NSW RURAL FIRE SERVICE

Your Ref: SSD 7198
Our Ref: DA-2019-01301

6 August 2020

Moonee Beach Residential Subdivision (SSD 7198) – Lot 1 DP 1097743, Pacific Highway, Moonee Beach

ROAD 7 - LONG SECTION

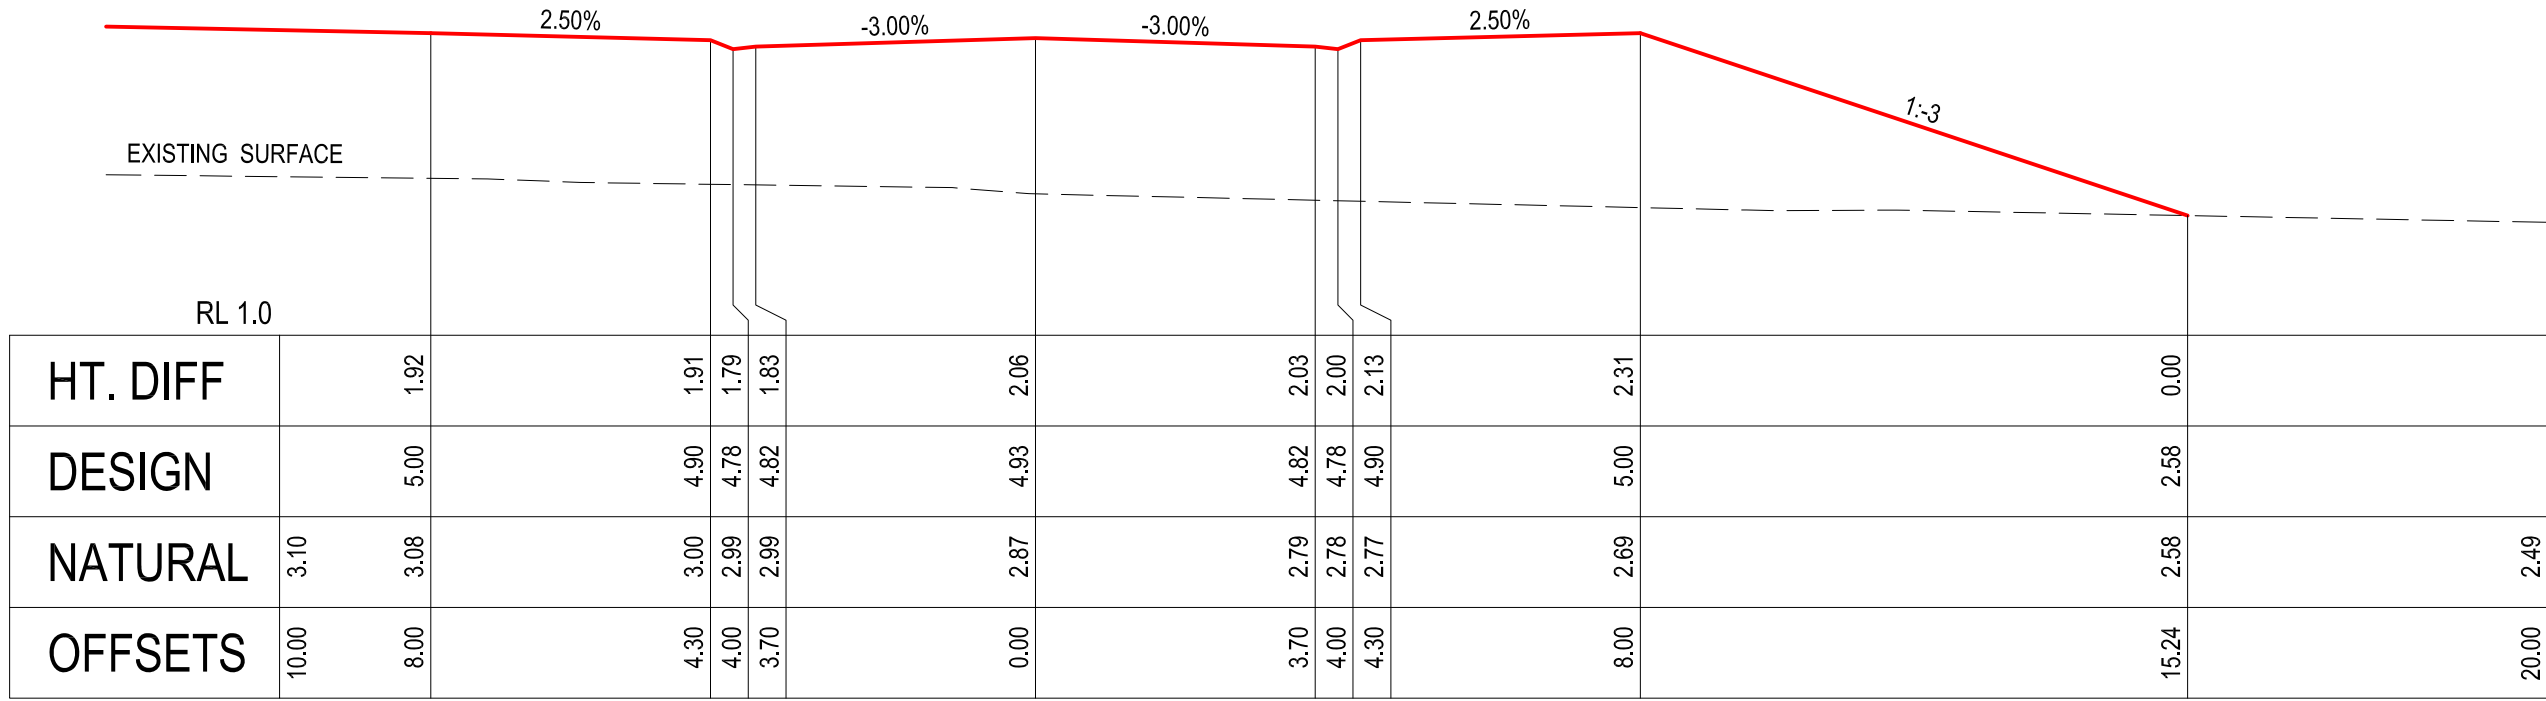
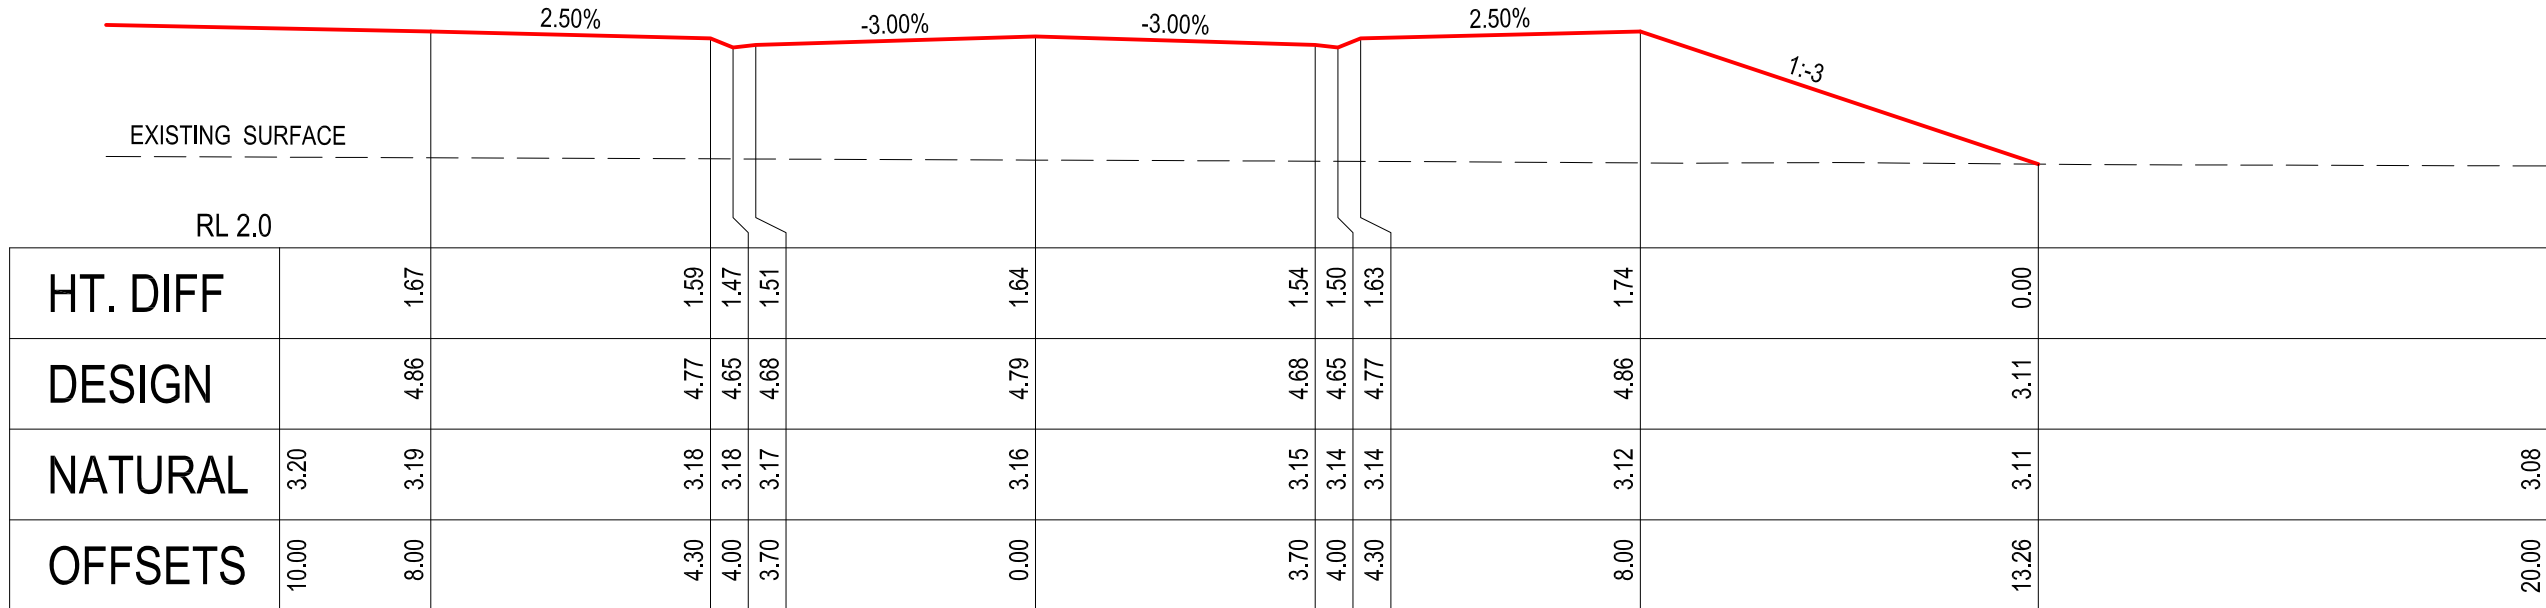
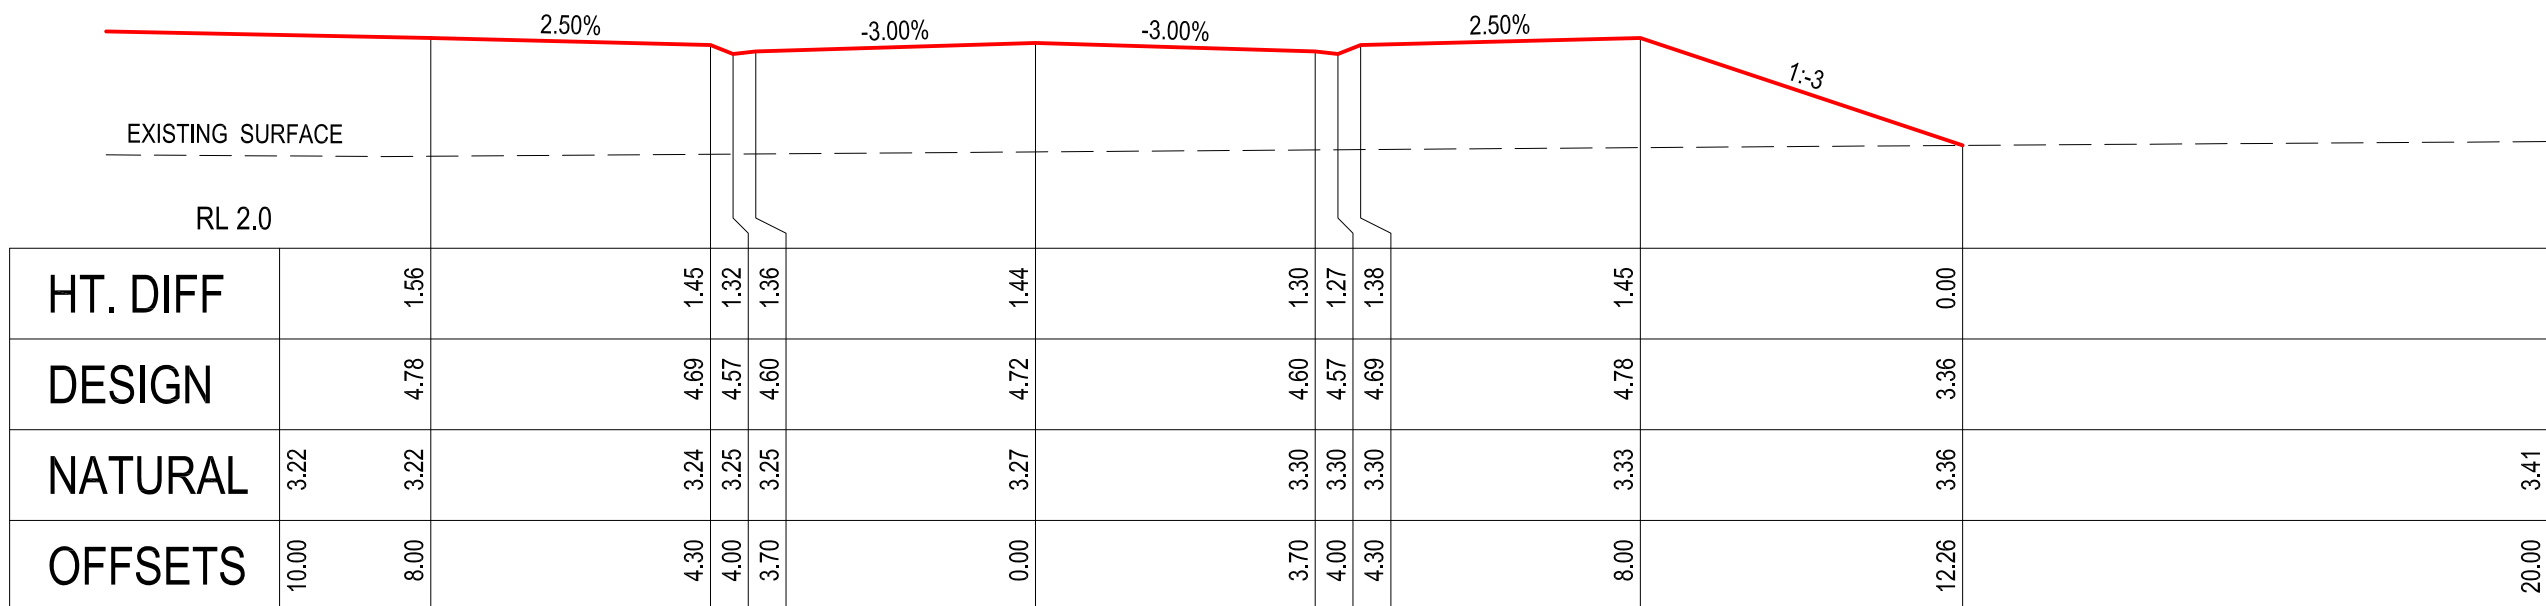
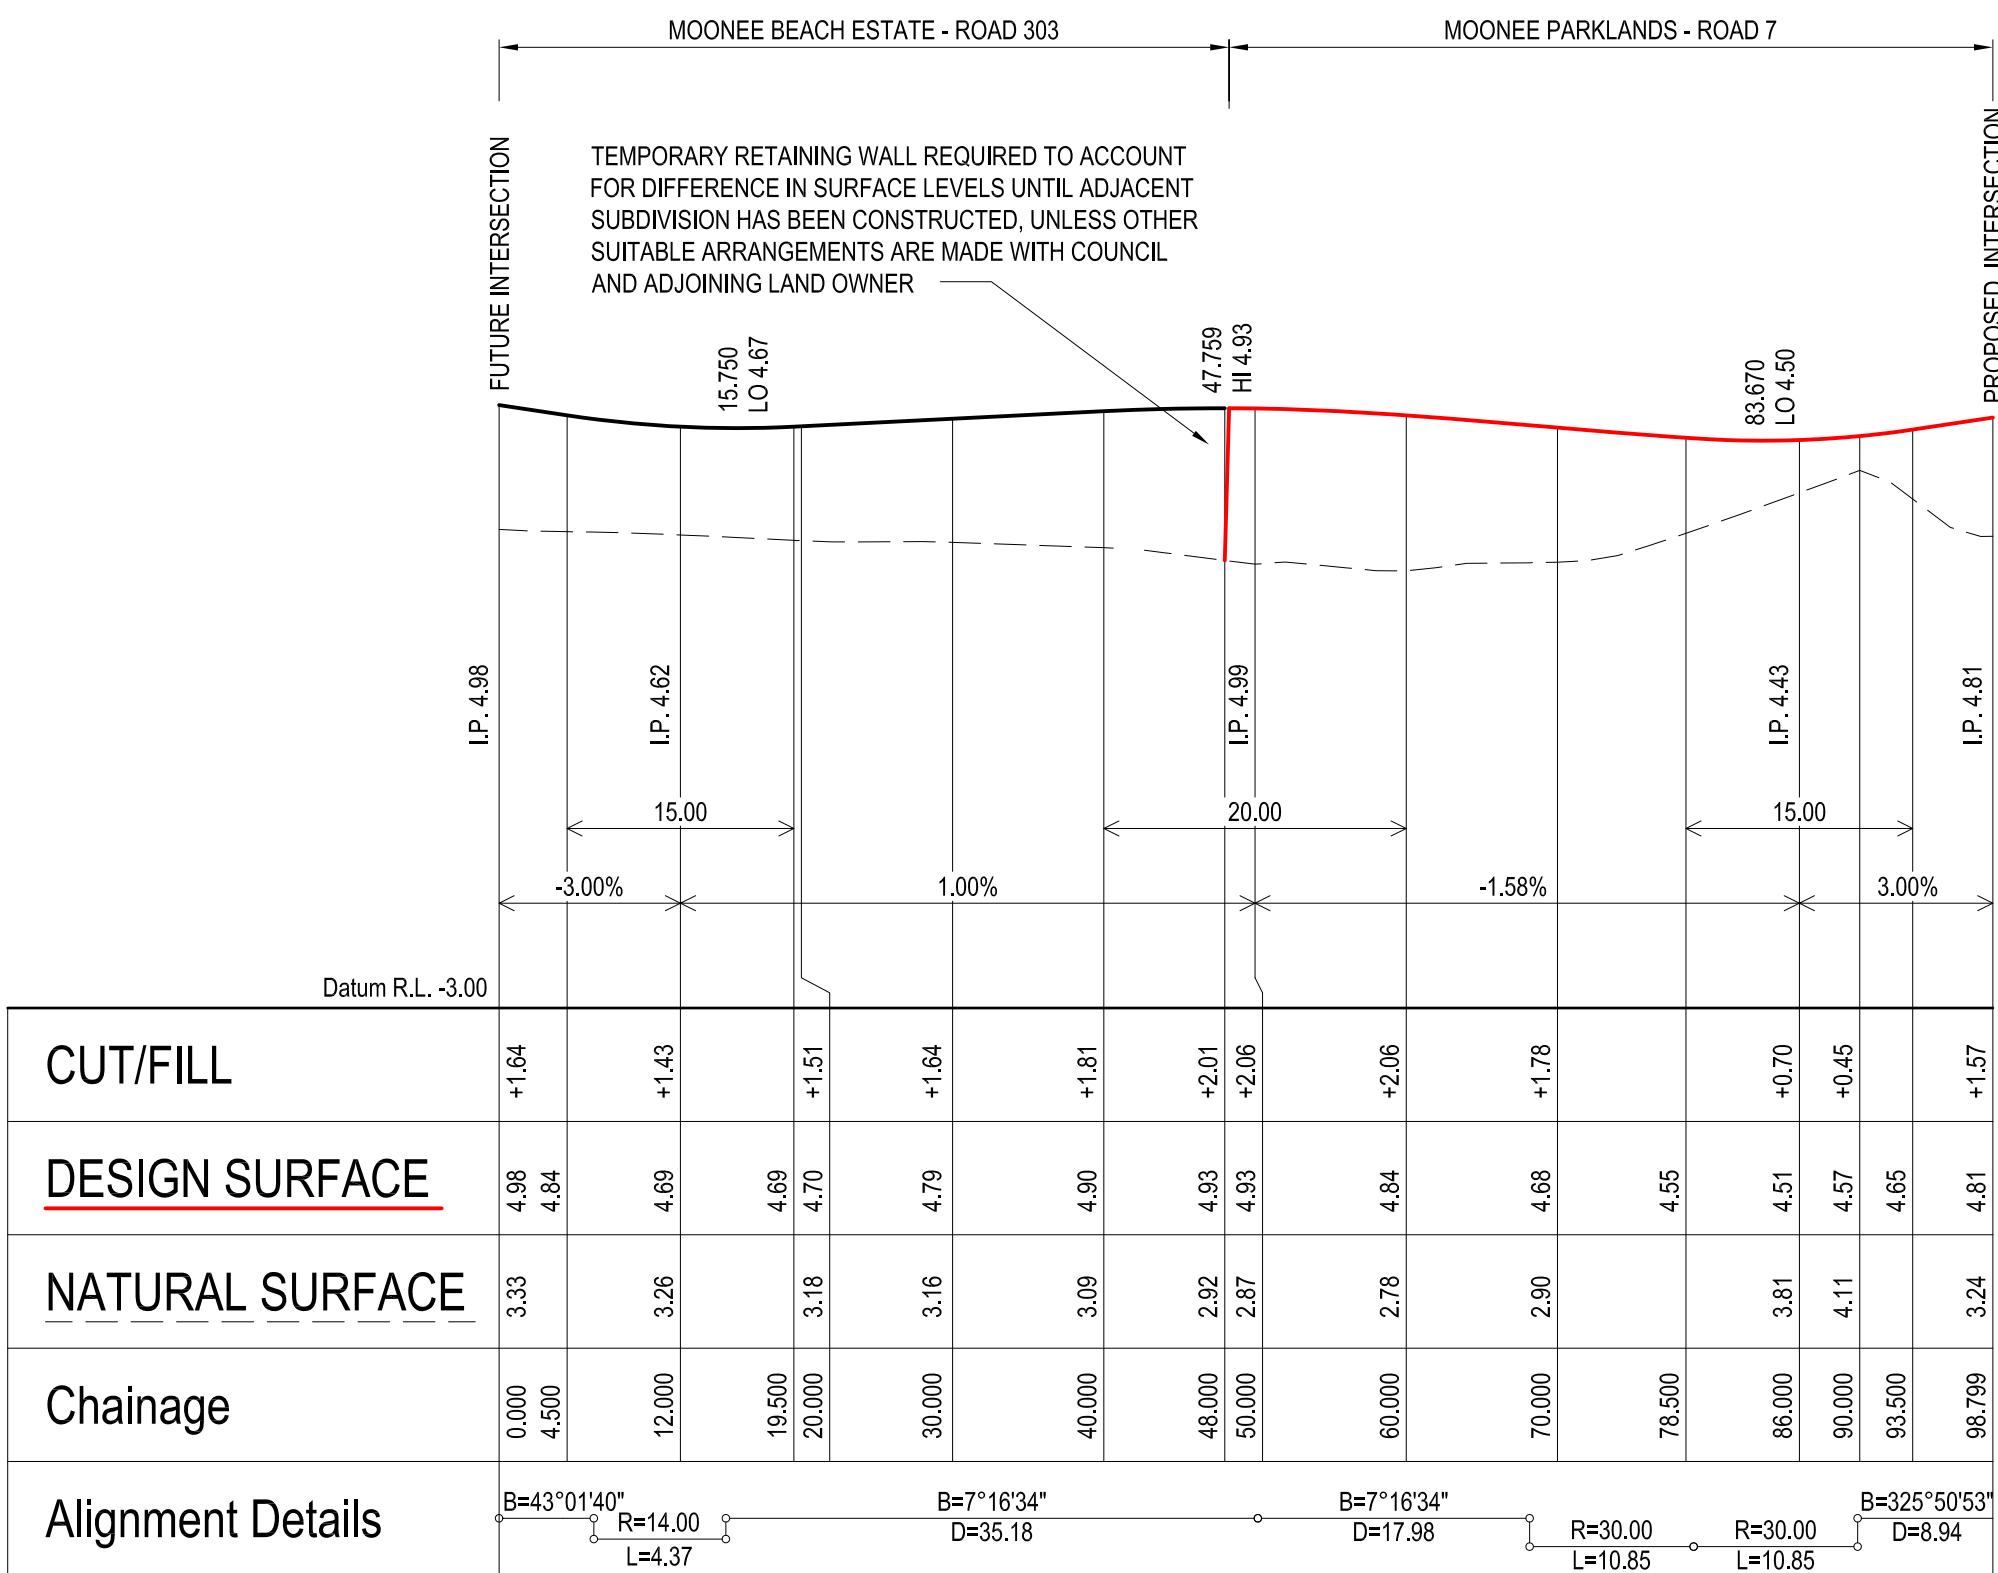
The NSW RFS also notes that the amended subdivision layout includes a new Road 7, providing access to the adjoining land to the south. No objection is made to this amendment.

8. Public road access shall comply with section 4.1.3 (1) of 'Planning for Bush Fire Protection 2006'.
9. Any temporary cul-de-sac created in the respective stages of the development shall provide an all-weather 12 metre outer radius turning circle.
